A303 Sparkford to Ilchester Dualling Scheme TR010036

8.10 Draft Statement of Common Ground with Queen Camel, West Camel and Sparkford Parish Councils

STATEMENT OF COMMON GROUND

Version	Date	Status of Version
Rev 1	January 2019	Draft for Examination Issue

Drawing Title
**FIGURE 2.4
RIGHTS OF WAY AND ACCESS PLANS - KEY PLAN
REGULATION 5(2)(k) and 5(2)(o)**

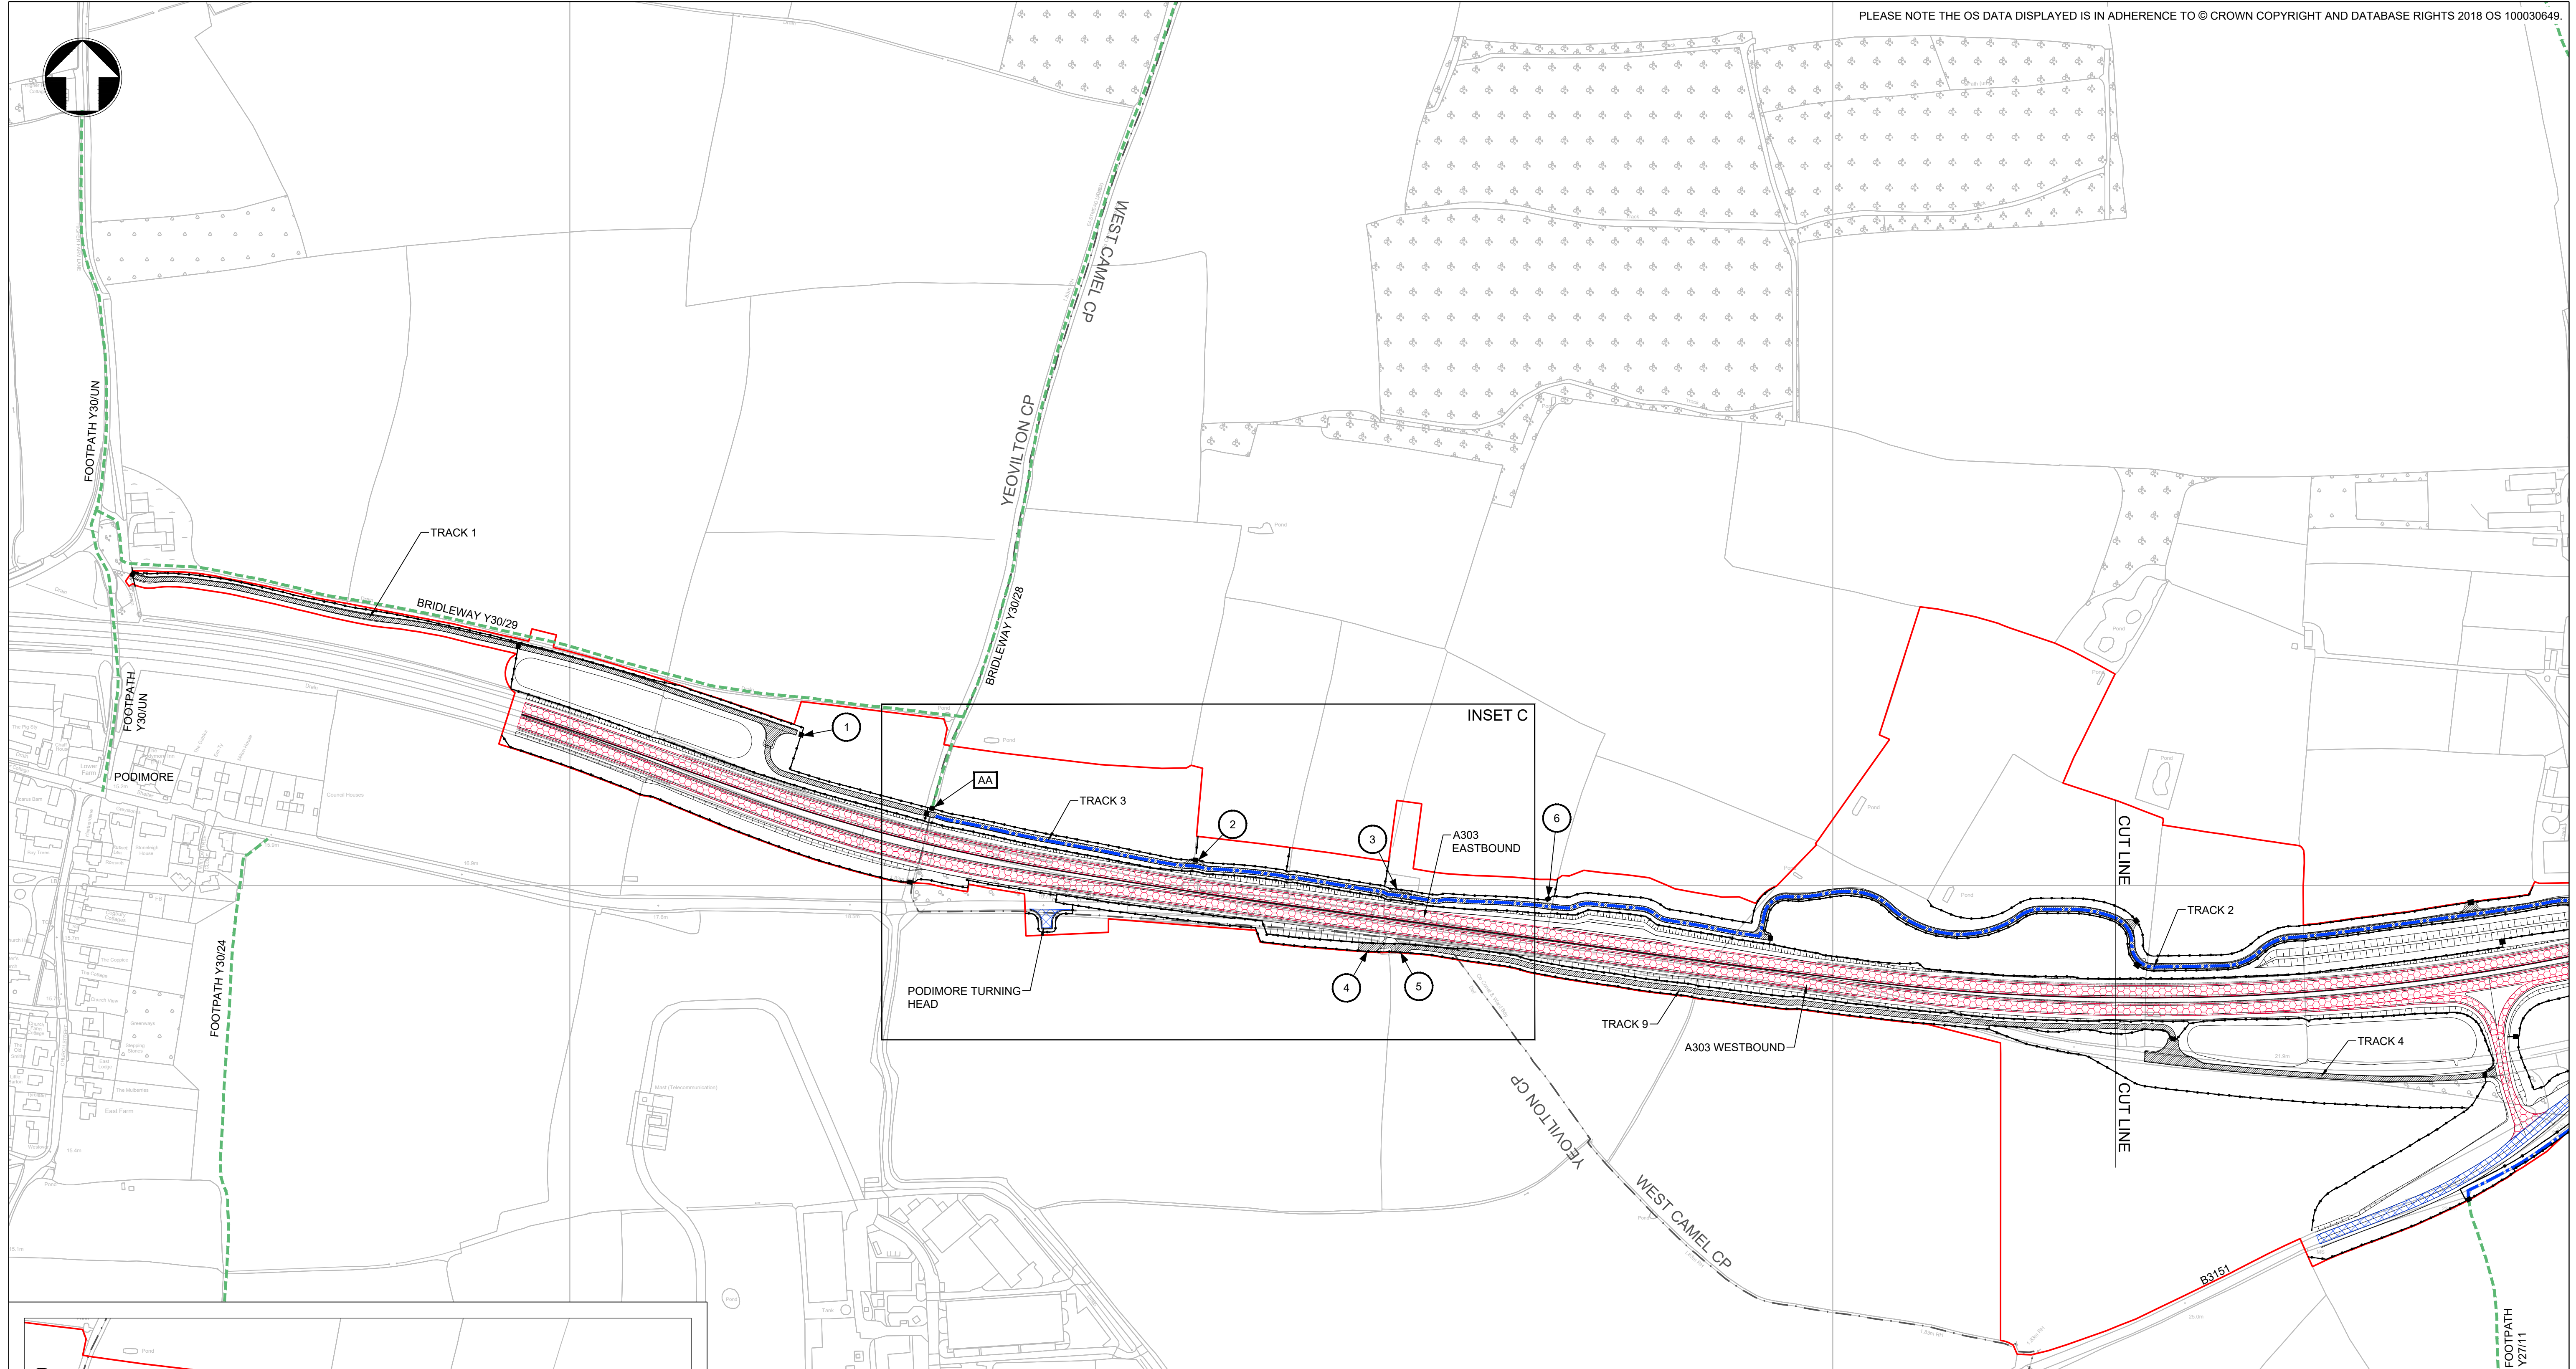
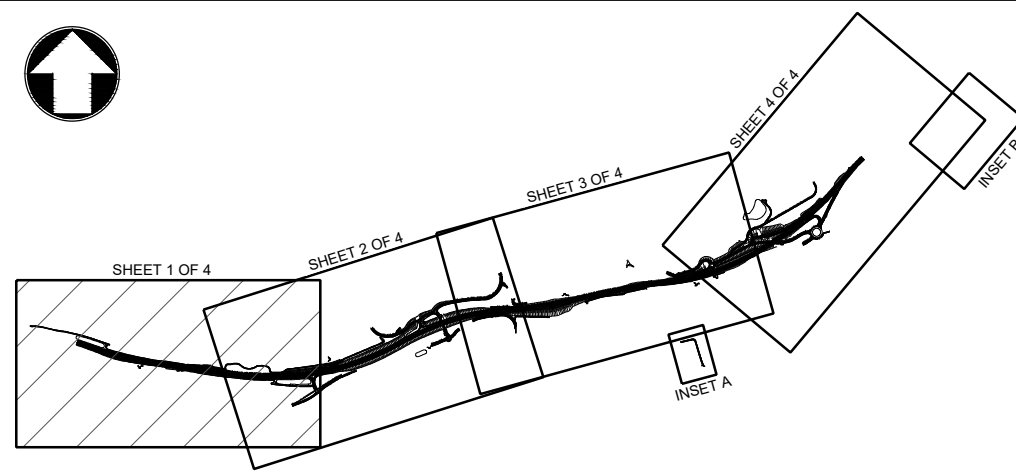
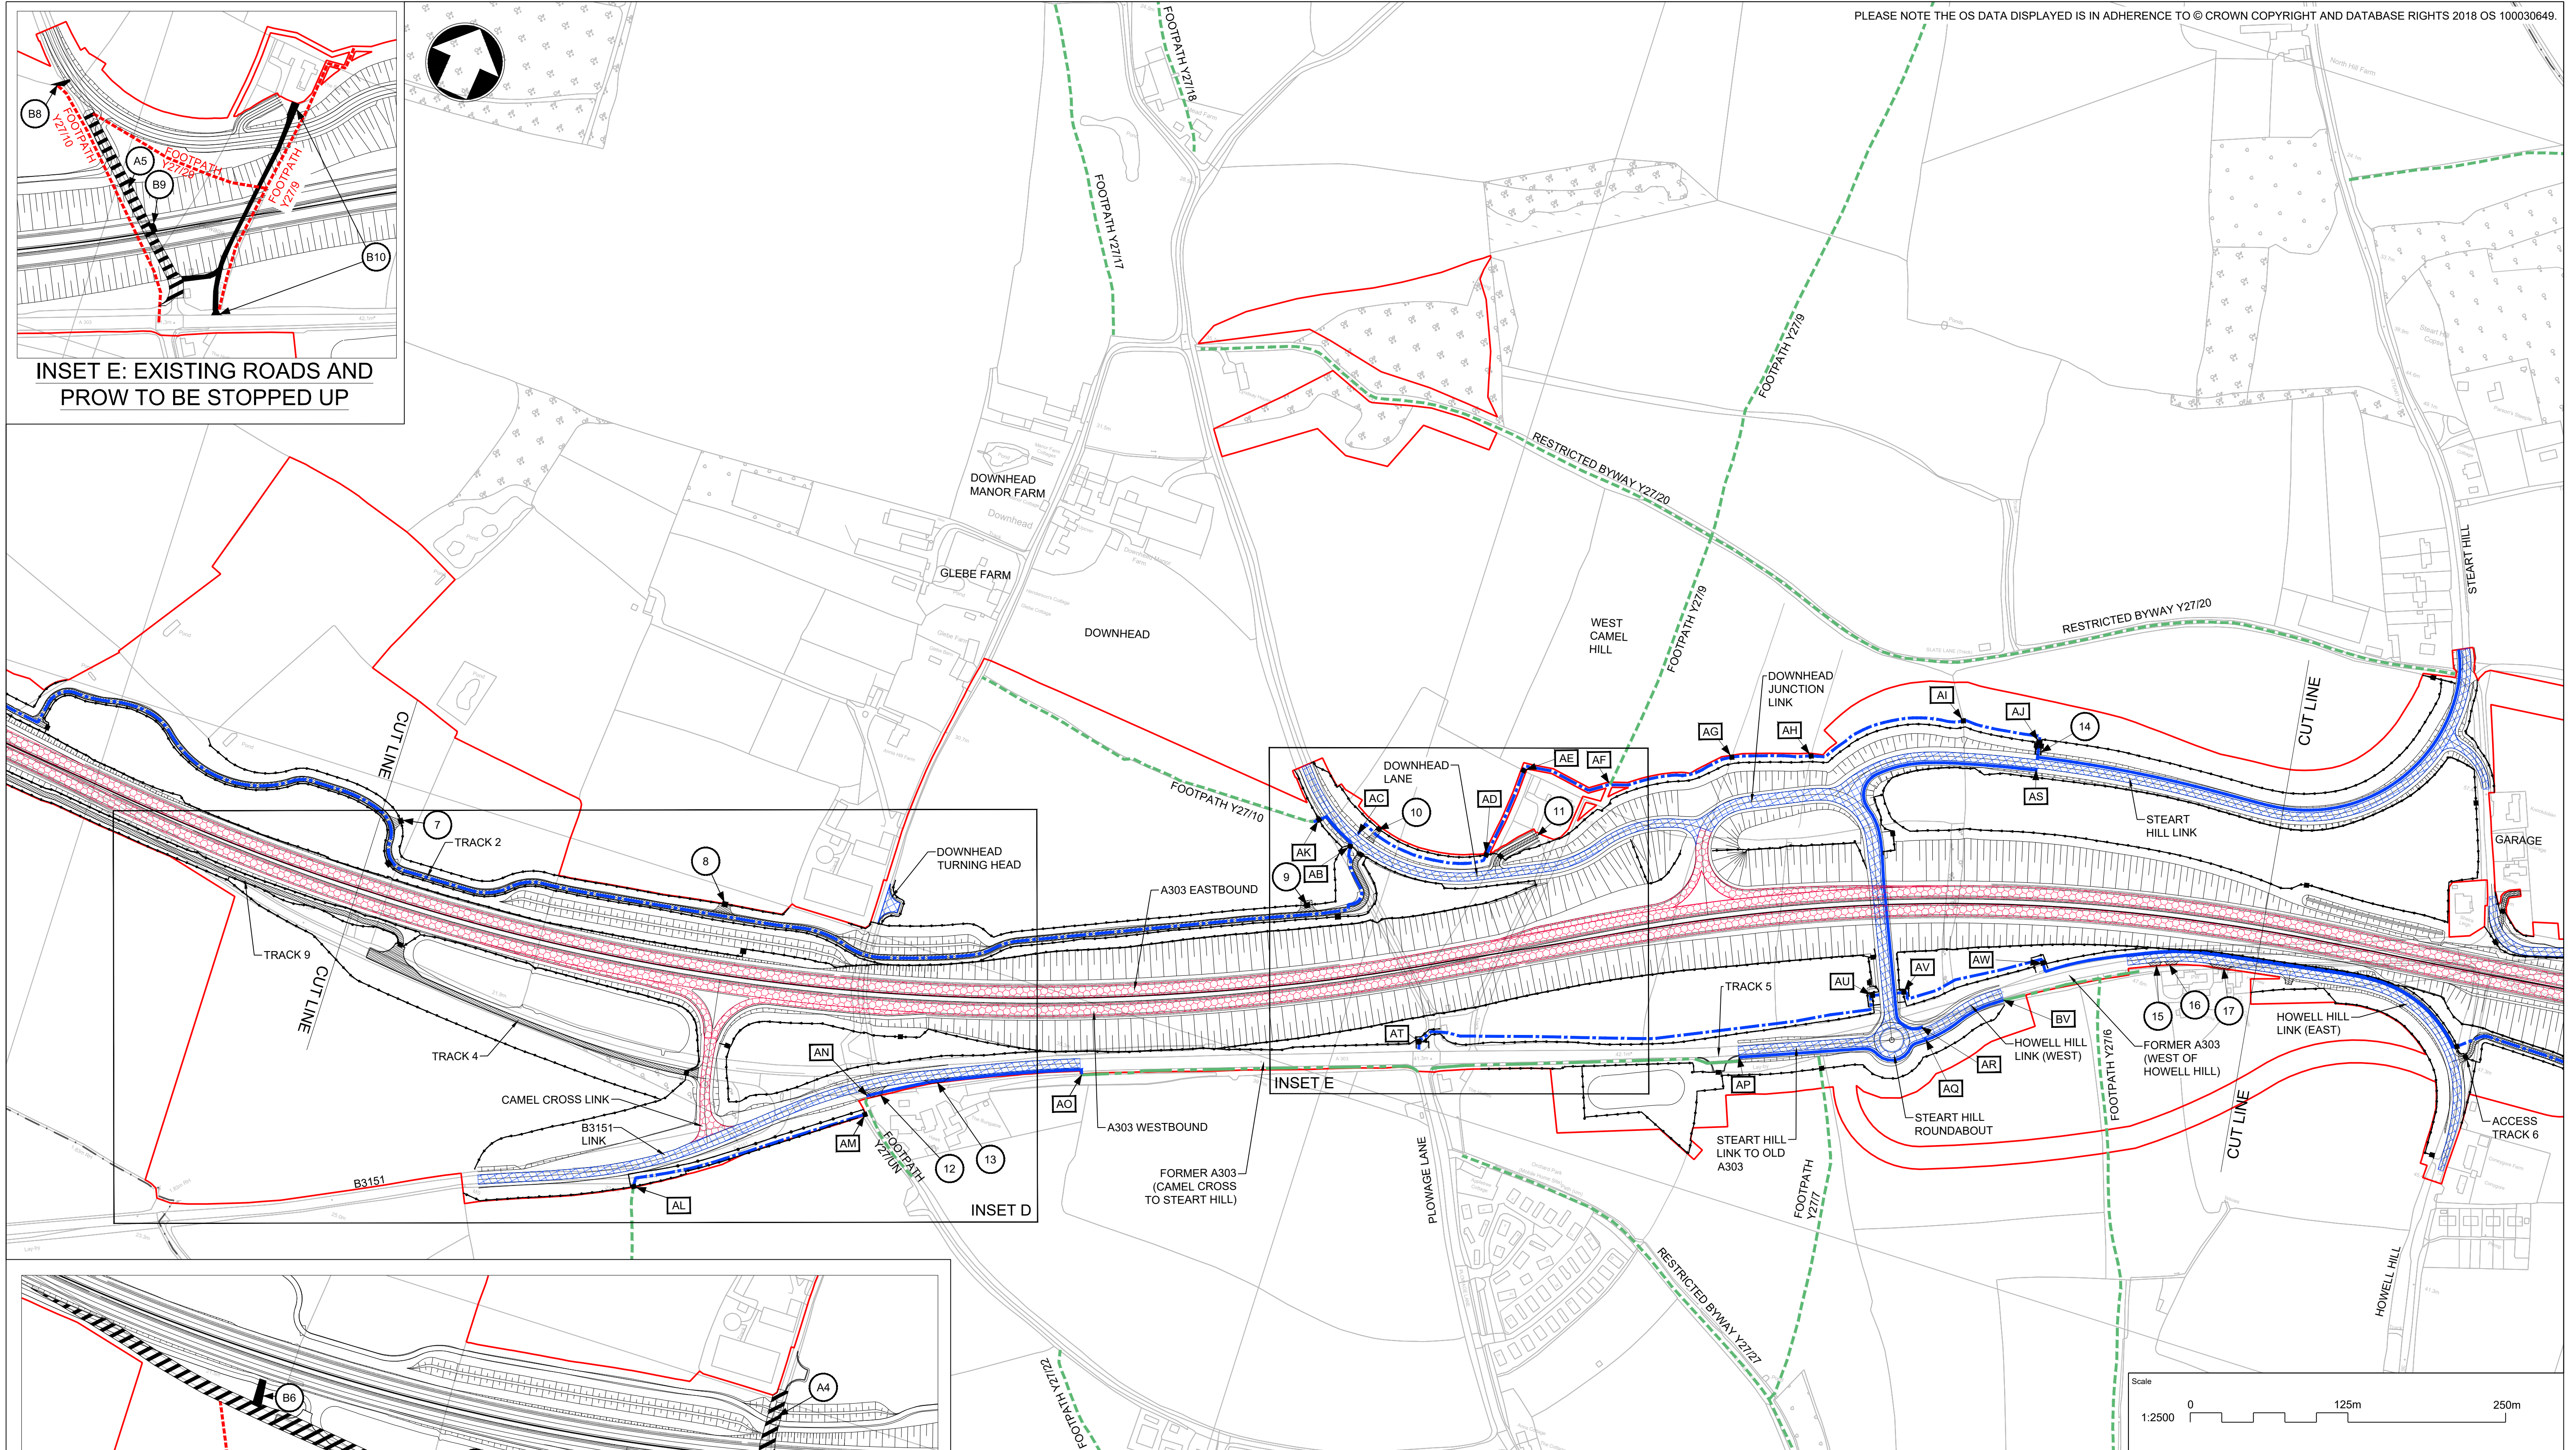
Public Rights of Way	The public rights of way will also be affected and protracted by the poor design of the Hazlegrove junction with walkers and horse riders forced to walk or ride along access roads to join rights of way within Hazlegrove park. Sparkford PC are still concerned with the poor design of the slip roads and that the under bridge will have no lighting during the periods of darkness.	A dedicated non-motorised user (NMU) route has been provided alongside the local road carriageway at the underbridge. This route will be segregated from motor traffic. It has been provided on the southern verge of the local road deliberately in order to avoid crossings of the eastbound merging slip road and the Hazlegrove School access.	UNDER DISCUSSION
